APPLICATION **LY/15/18/DOC**
NO:

Registered: 24-JUL-18
Site Address: Crossbush Farm Shop Lyminster Road Lyminster BN17 7QN

Description of Works: Approval of details reserved by condition imposed under LY/28/17/PL relating to conditions 5-equipment to control odour/fumes, 9-secured & covered cycle parking & 11- closing of Calceto Lane for egress of vehicles.

PRJ NR REWE		Page 2/3	
TITLE W1A roaster with SFE25 filter		REV 04	
DRAWER MW	DATE 07-09-2017

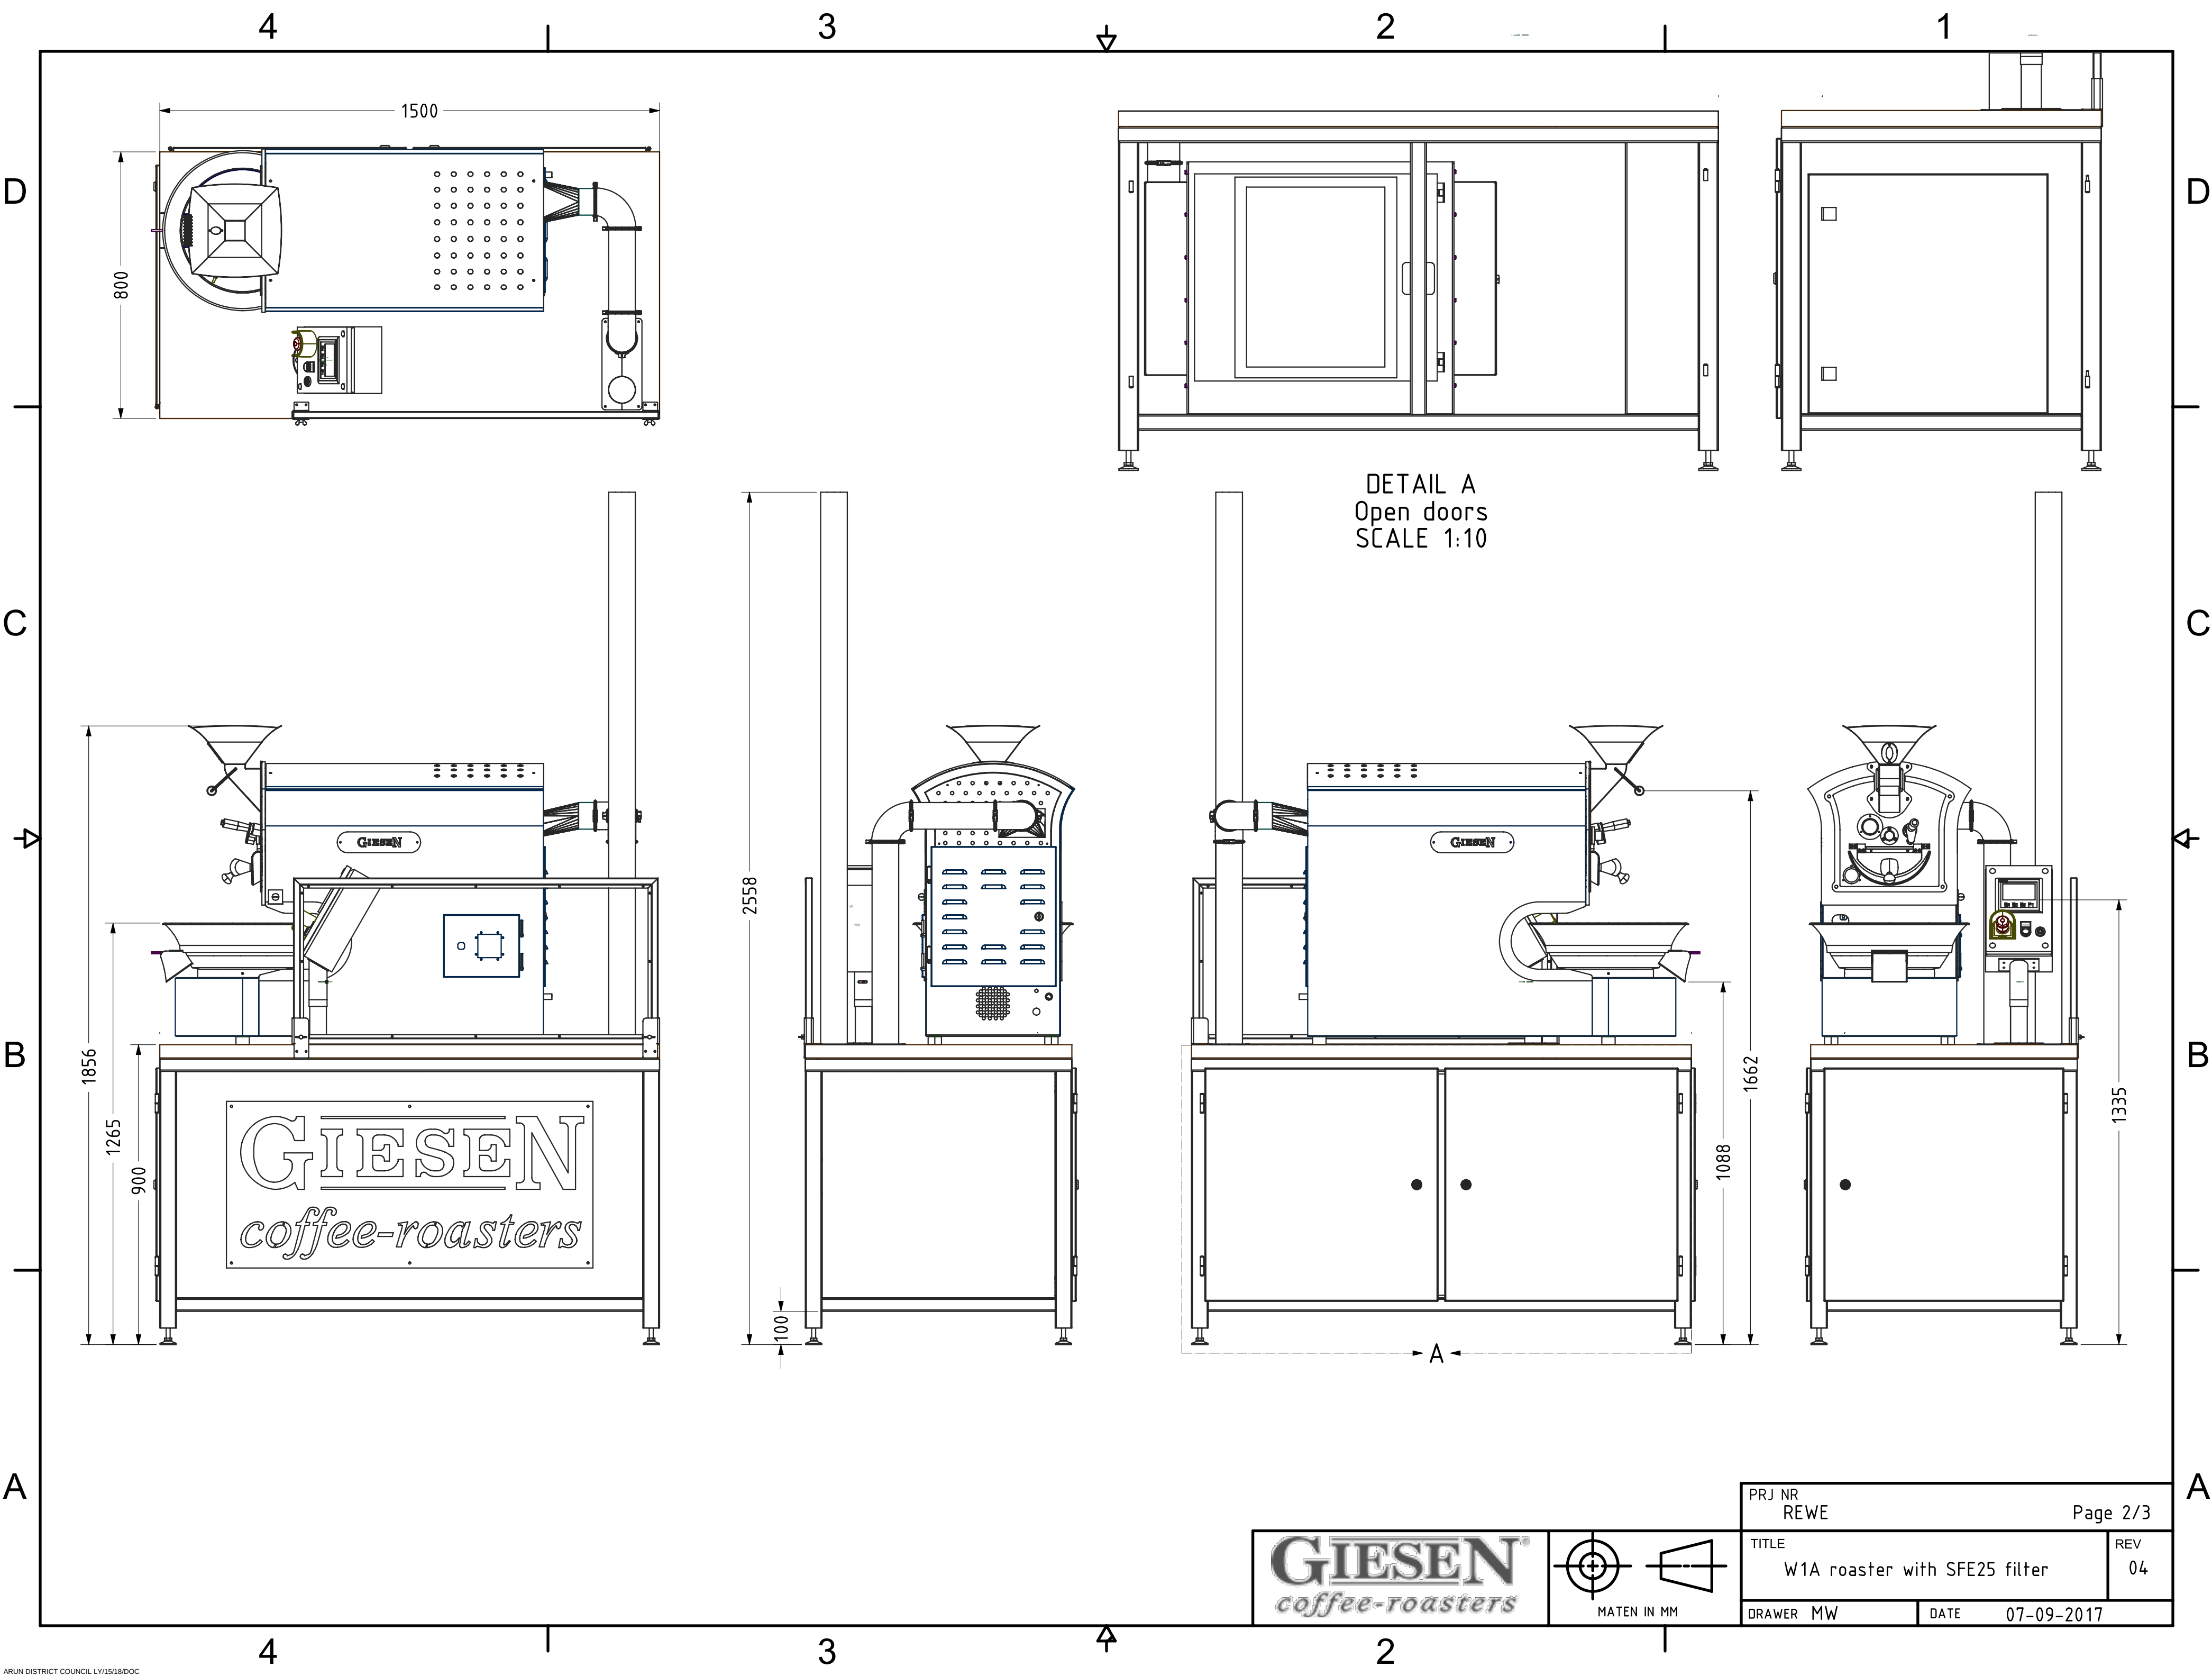
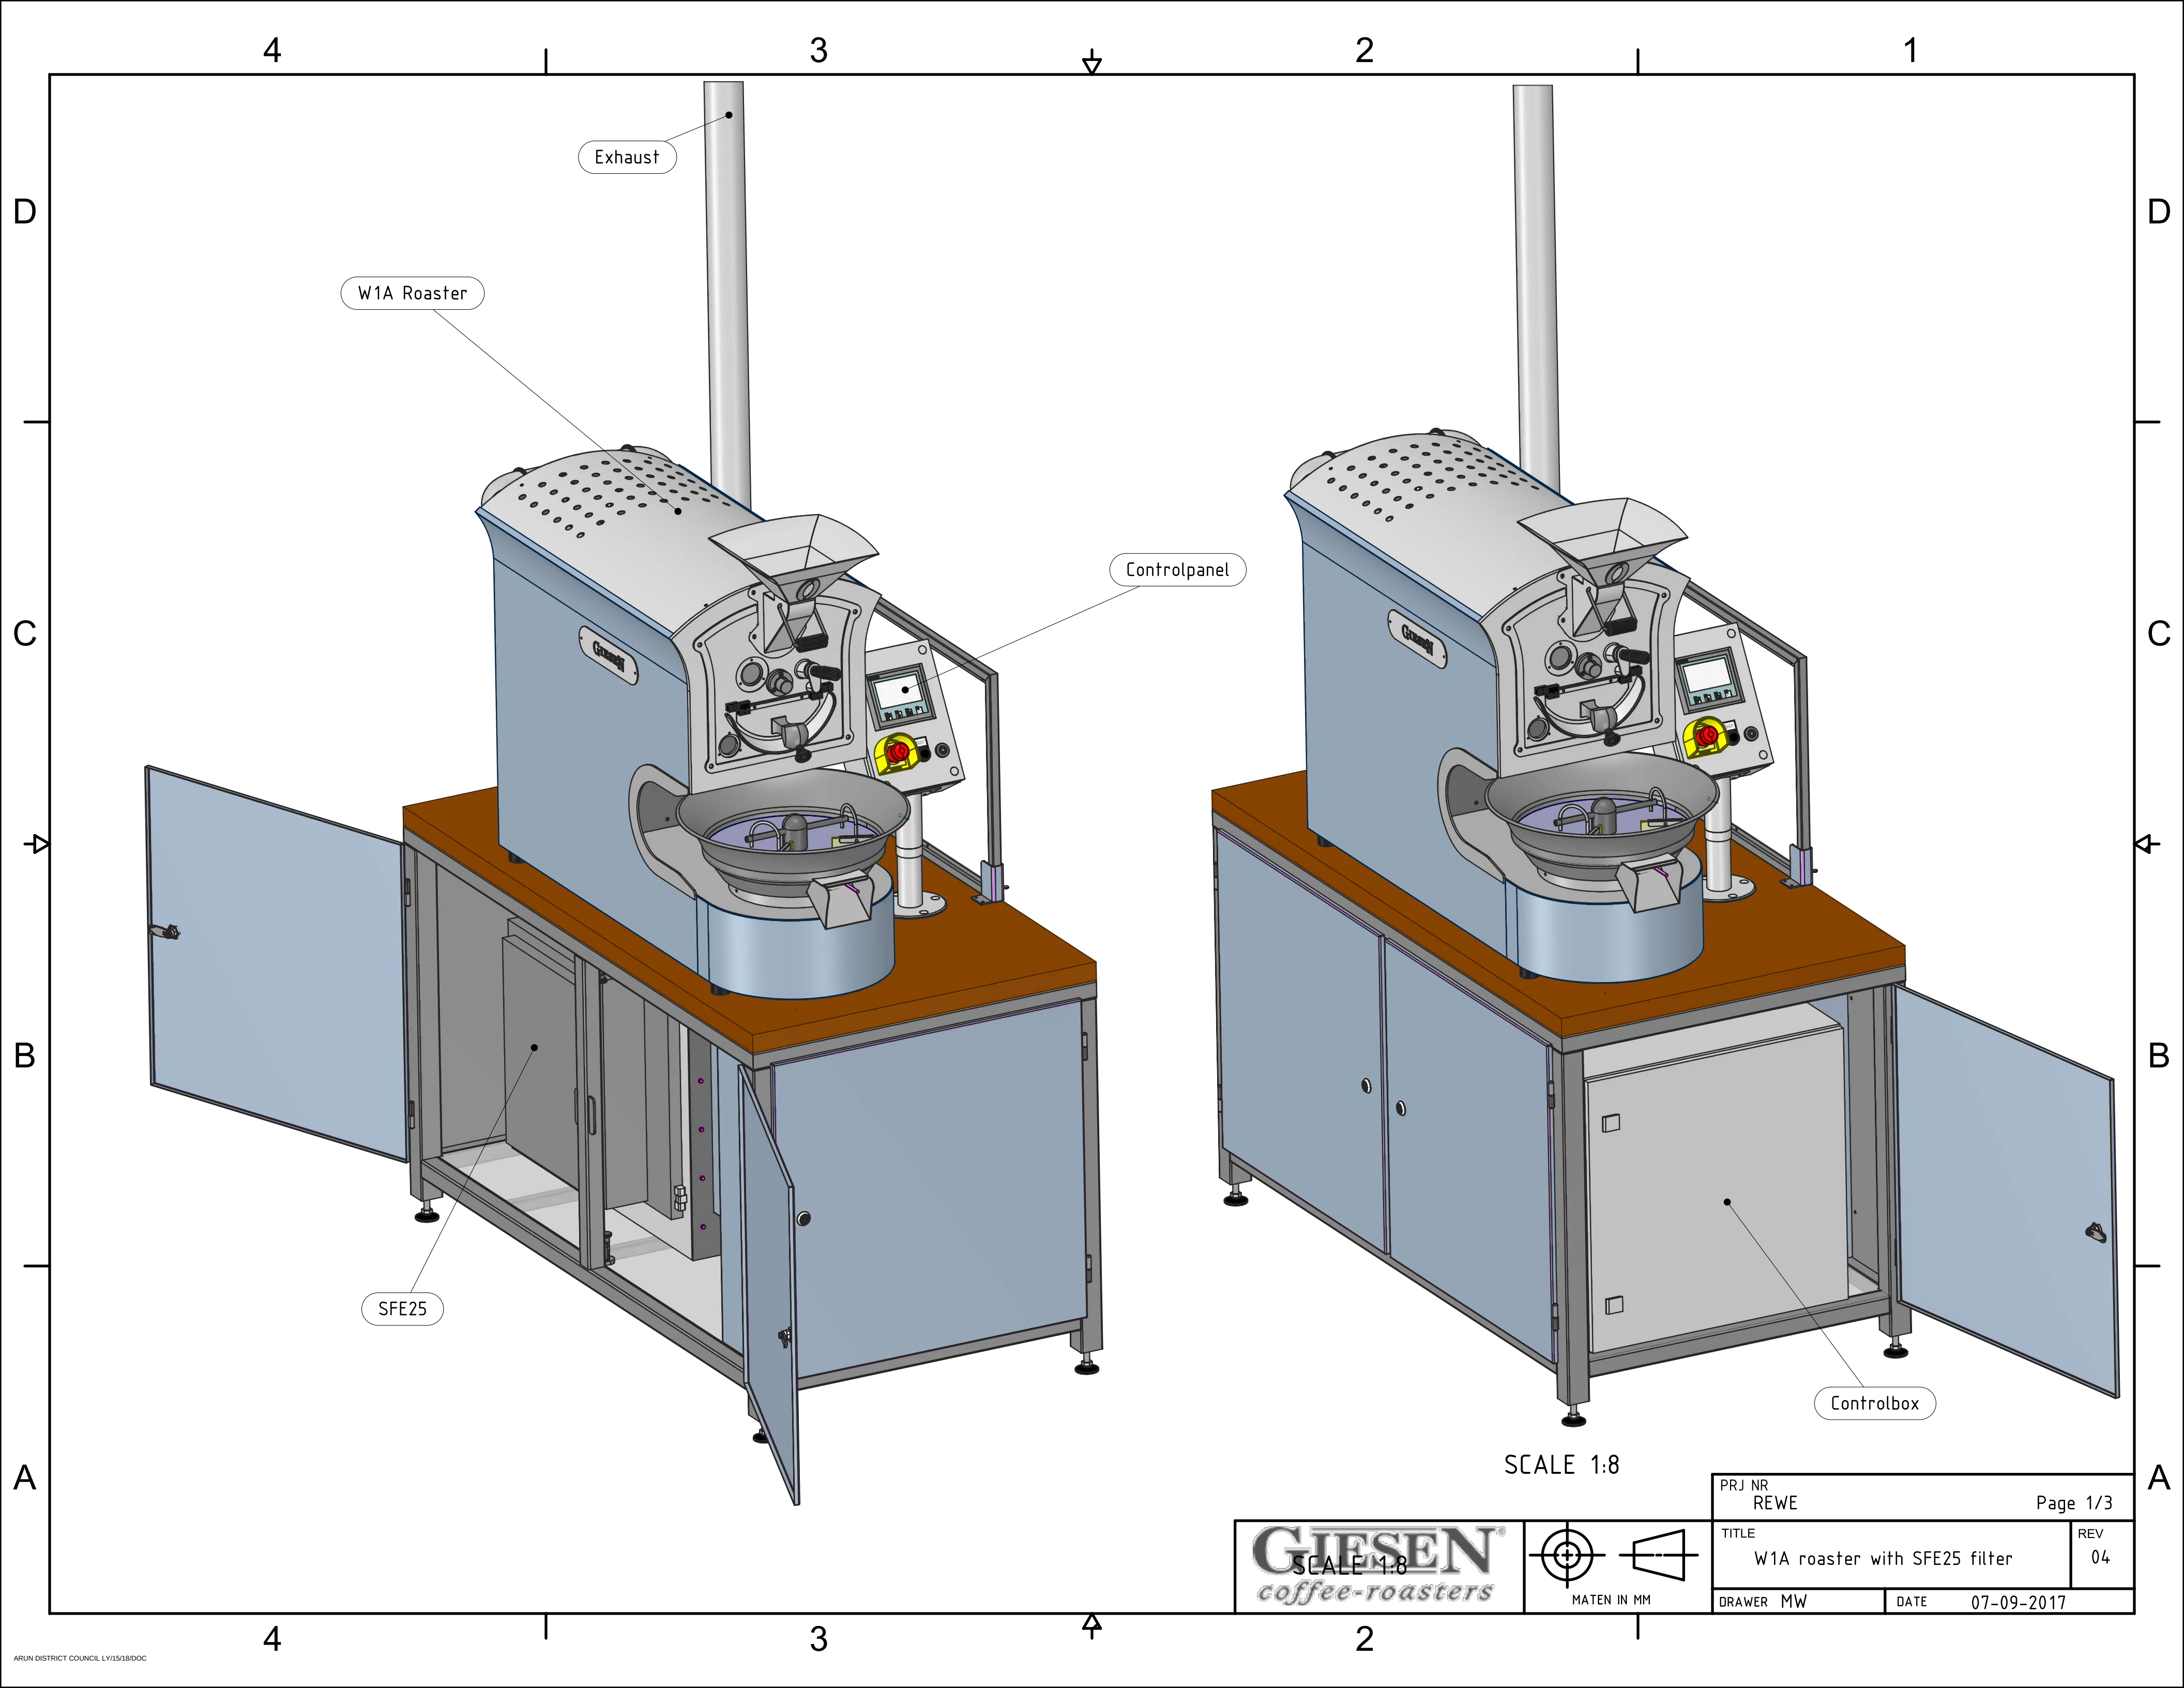
Environmental Health: Agree to discharge of condition 5 in respect of control of odour/fume. This is based on the stated provision of Geisson coffee roaster (which produces no odour) and odour abatement equipment comprising essentially 1 x 1MXB2 Maxicarb unit with retention time of not less than 0.3 seconds(or equivalent) and associated fan both to be fitted inside the building. The flue exit to be above eaves level and provided with a rotating cowl to maximise dispersion.
